City of Portland, Maine - Building or Use Permit Application
 389 Congress Street, 04101 Tel: (207) 874-8703, Fax: (207) 874-8716

Permit No: 09-0650	Issue Date:	CBL: 039 A013001
------------------------------	--------------------	----------------------------

Location of Construction: 600 CONGRESS ST	Owner Name: RICE GEOFFREY I	Owner Address: 658 CONGRESS ST 1ST FLOOR	Phone:
Business Name:	Contractor Name: property owner	Contractor Address:	Phone
Lessee/Buyer's Name	Phone:	Permit Type: Alterations - Commercial	Zone:

Re: Code Renovations
602 Congress Street

EXISTING-1.0

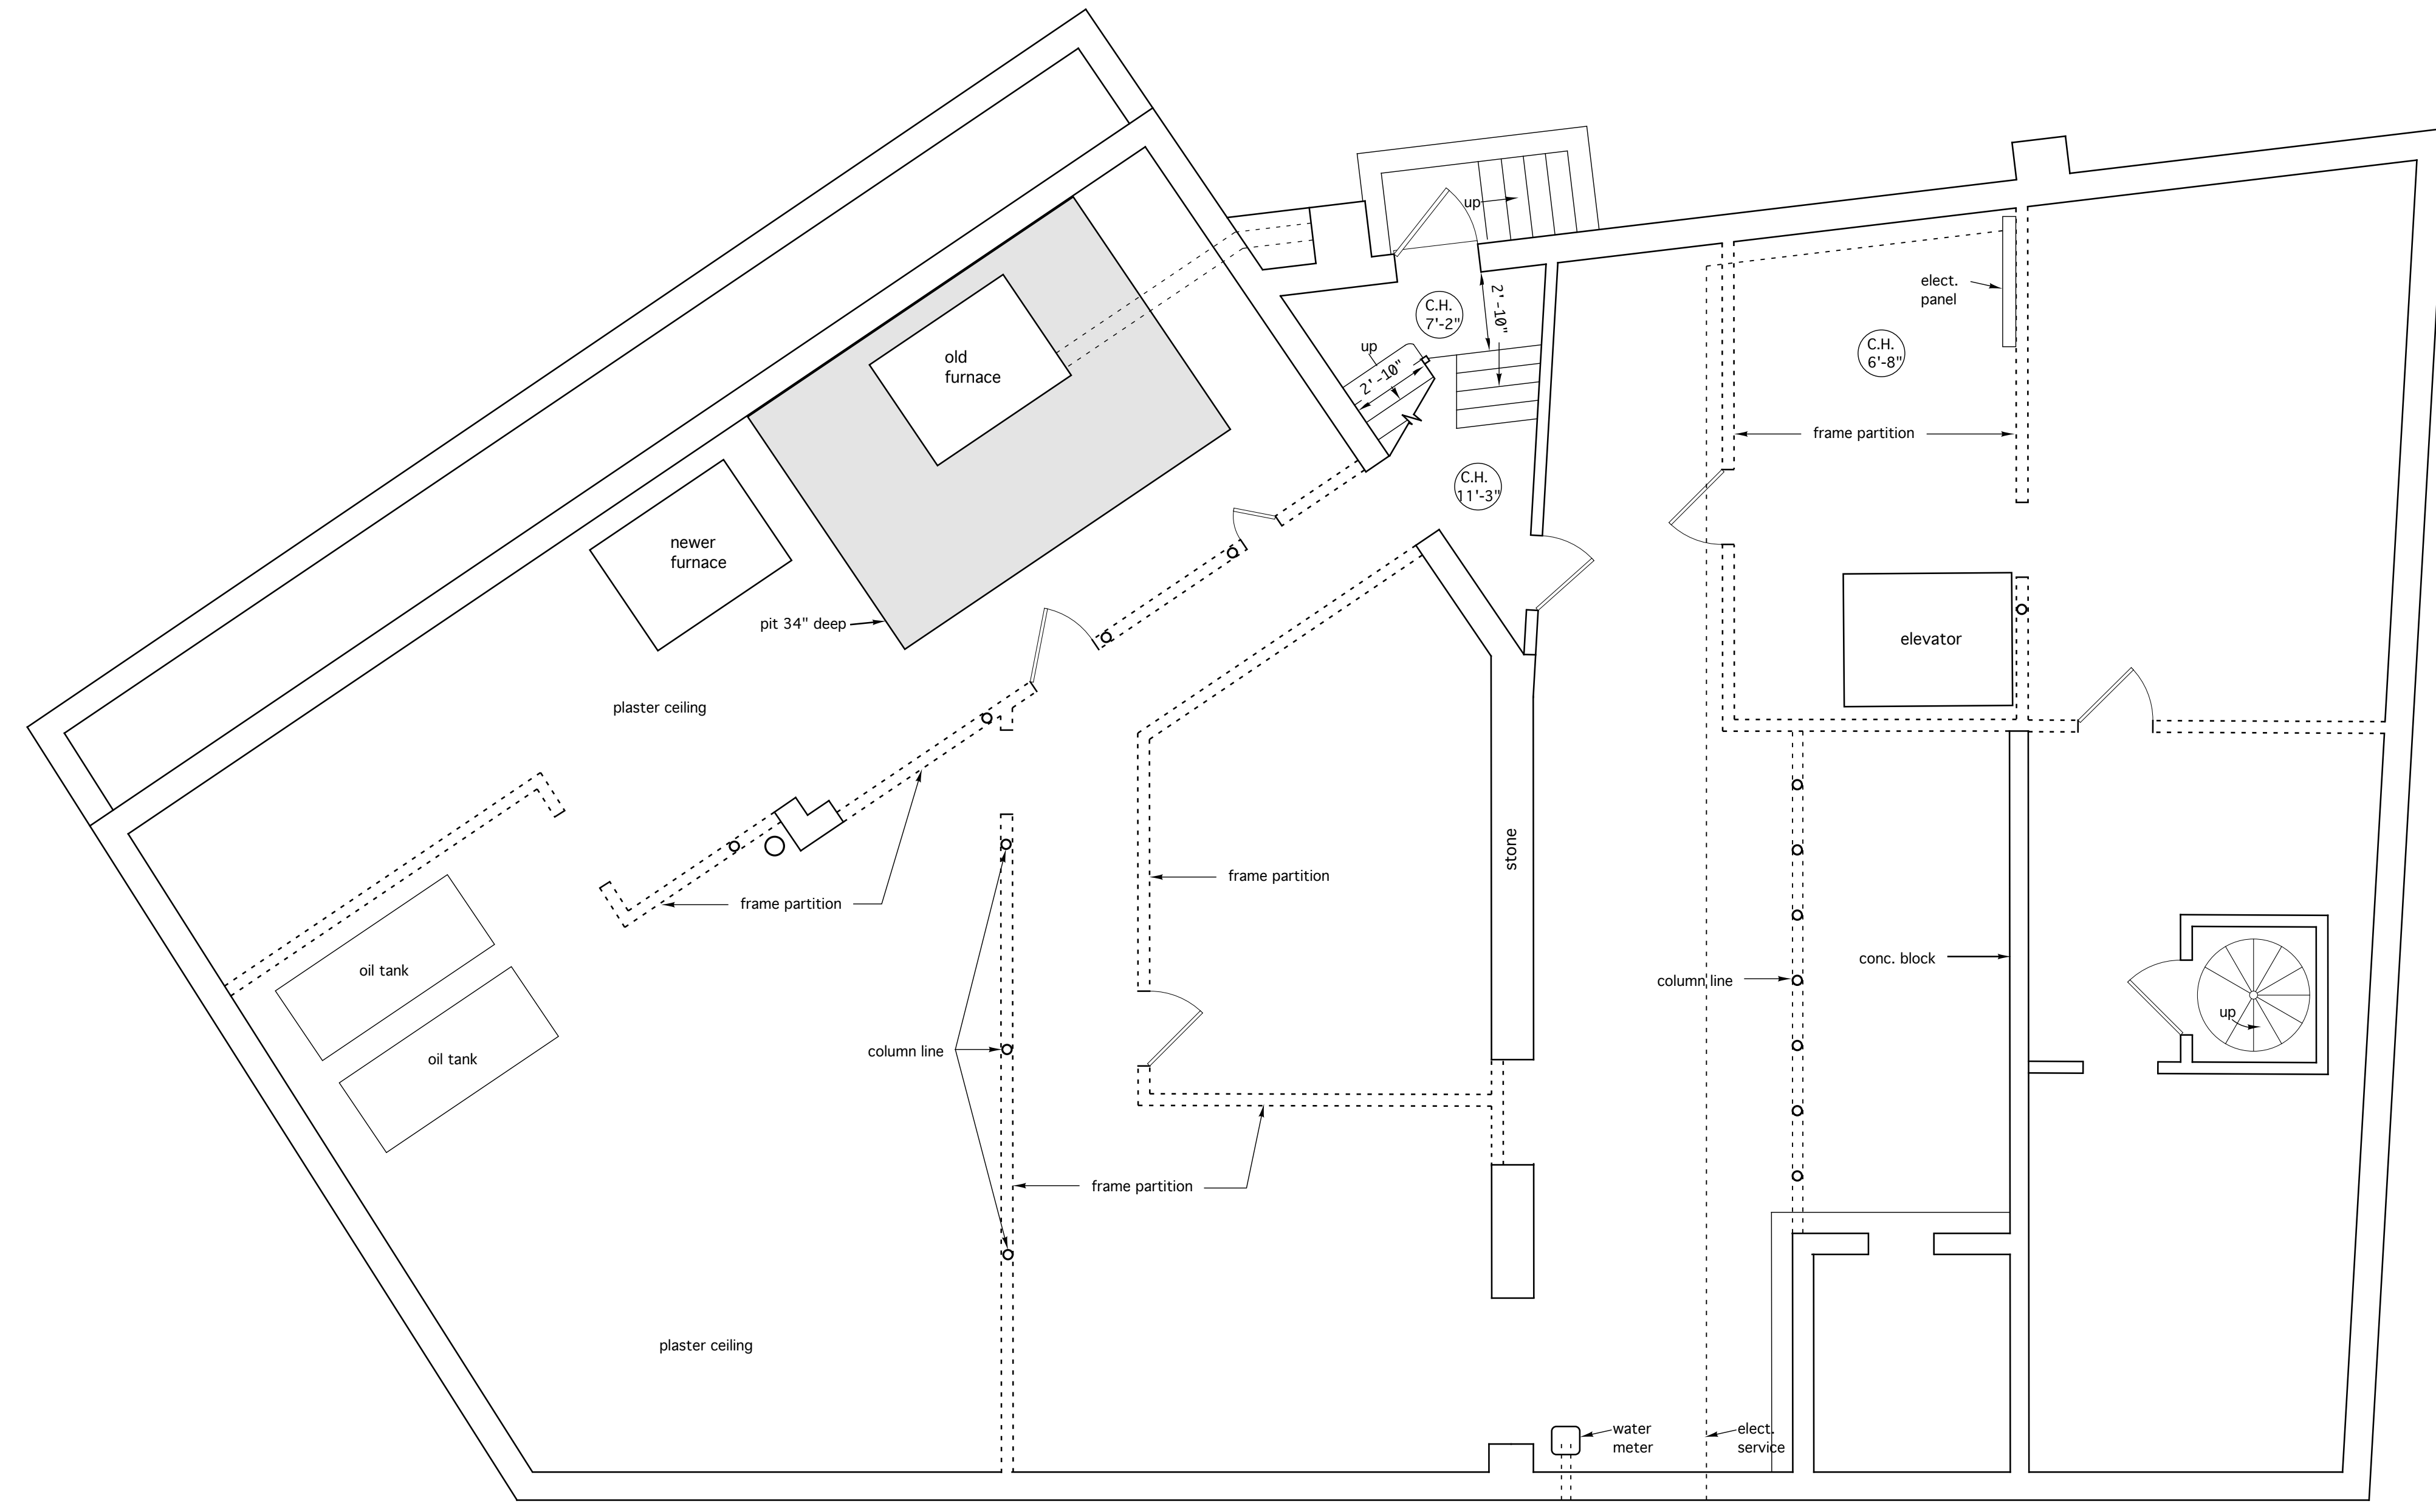
What is the rating of the spiral stair enclosure in Basement space 003? *sprinkler*

With the removal of the walls in the basement, is the space over 2,500 square feet? *N/A sprinkler*

A-1.1

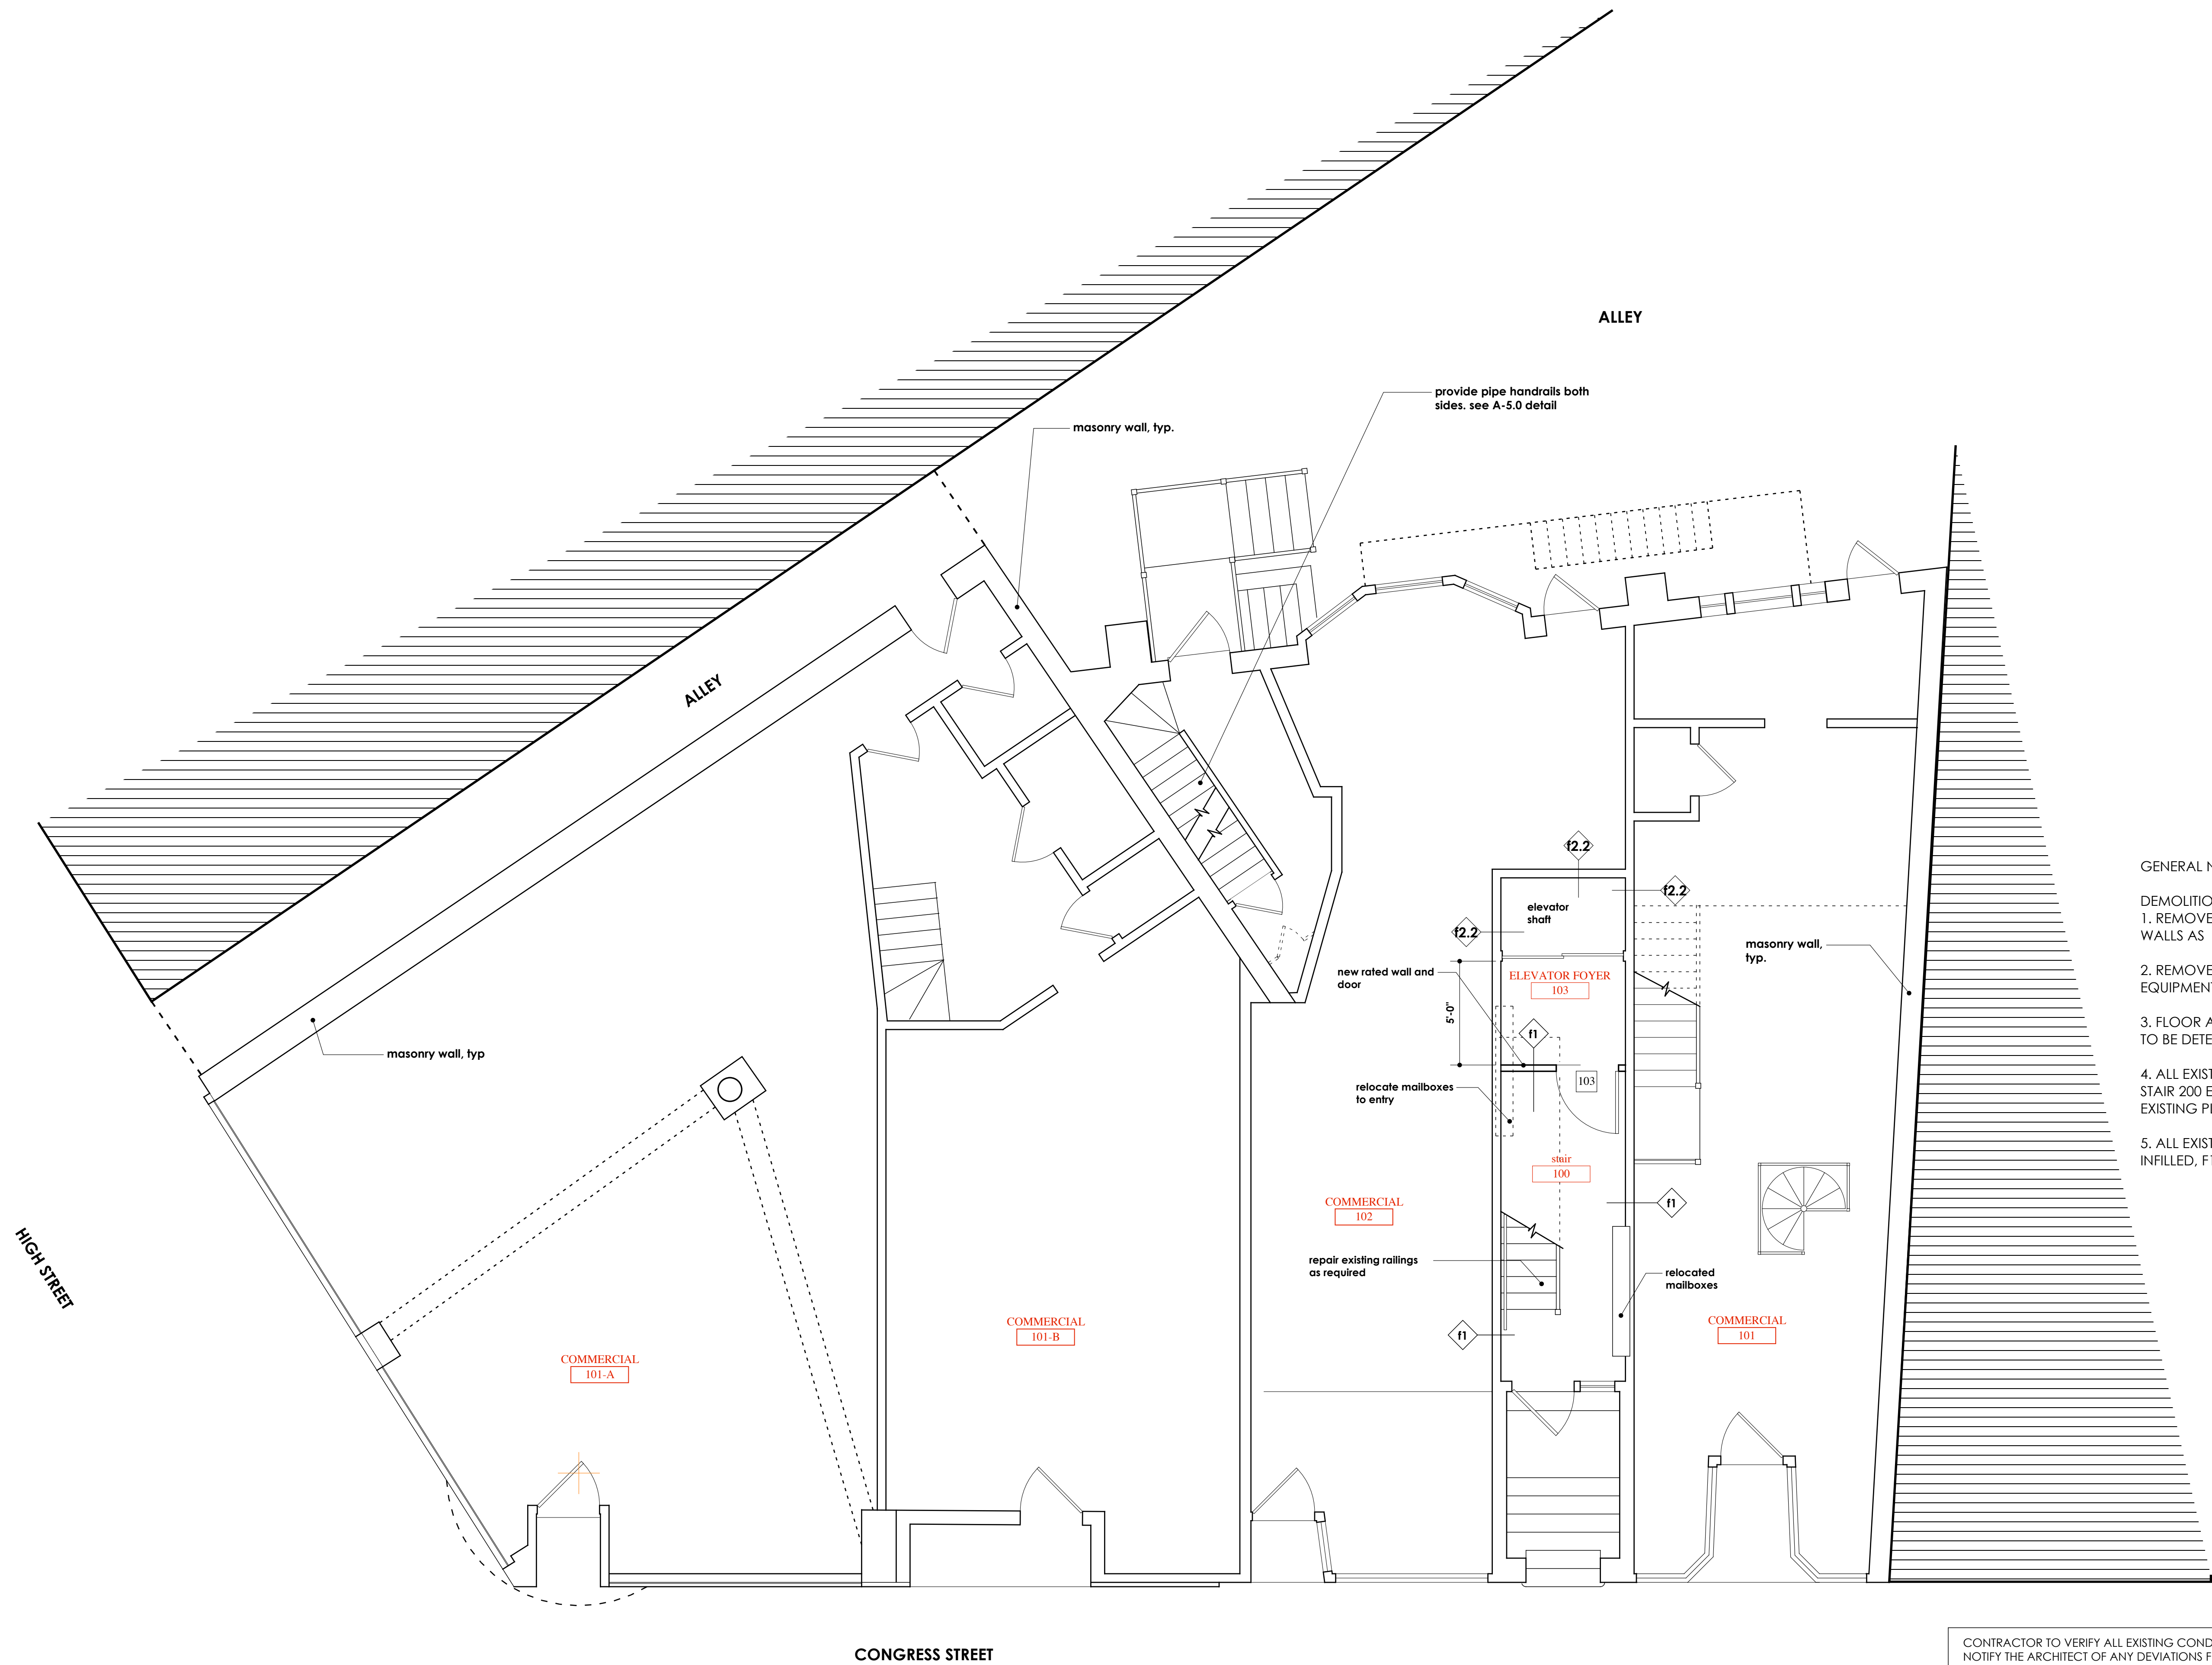
Where does the stair in commercial tenant space 101-A go? *Will review*

**A-5.0**

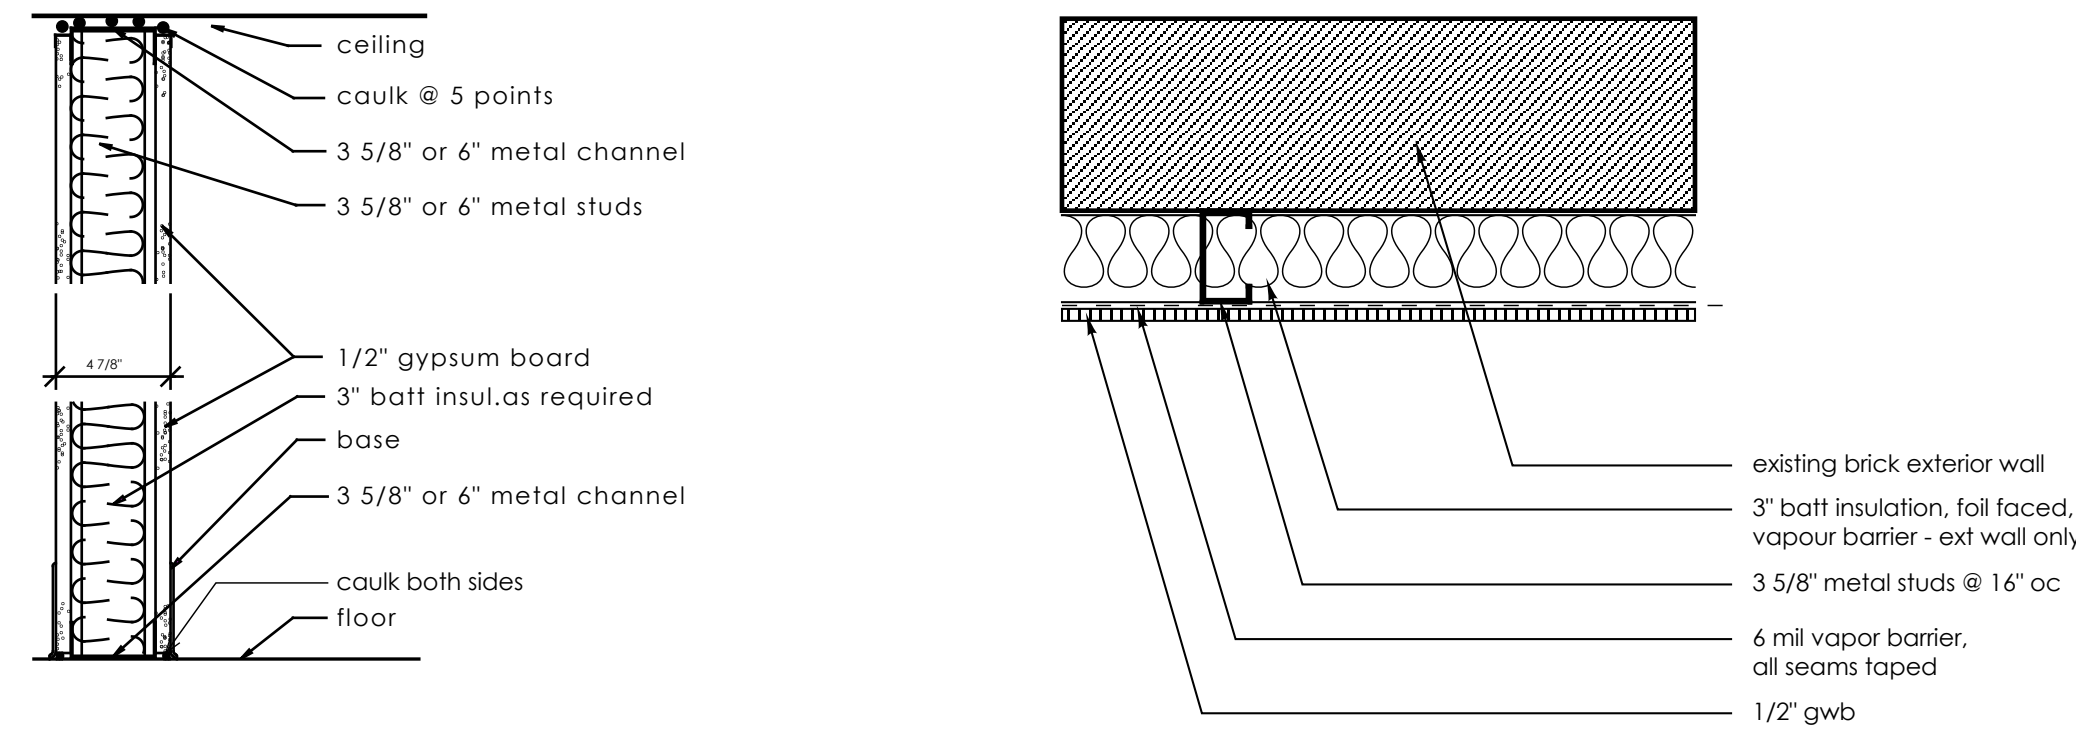
2/9/2010-jmb: Met with Ben W. To review plans, and his previous list of questions. Spoke with Jim S. About scope of work, he has new electrical plans from Harold. He is unsure of the extent of the removal of wall coverings so a condition will address any upgrades in stc ratings. He will also submit the design cert. Documents and revised plans. Discussed solid birch fire doors, he thought they would have rated steel assemblies.

All apt. doors to be 20-min. listed fire door assemblies.

All stair doors to be 60-min listed fire door assemblies.
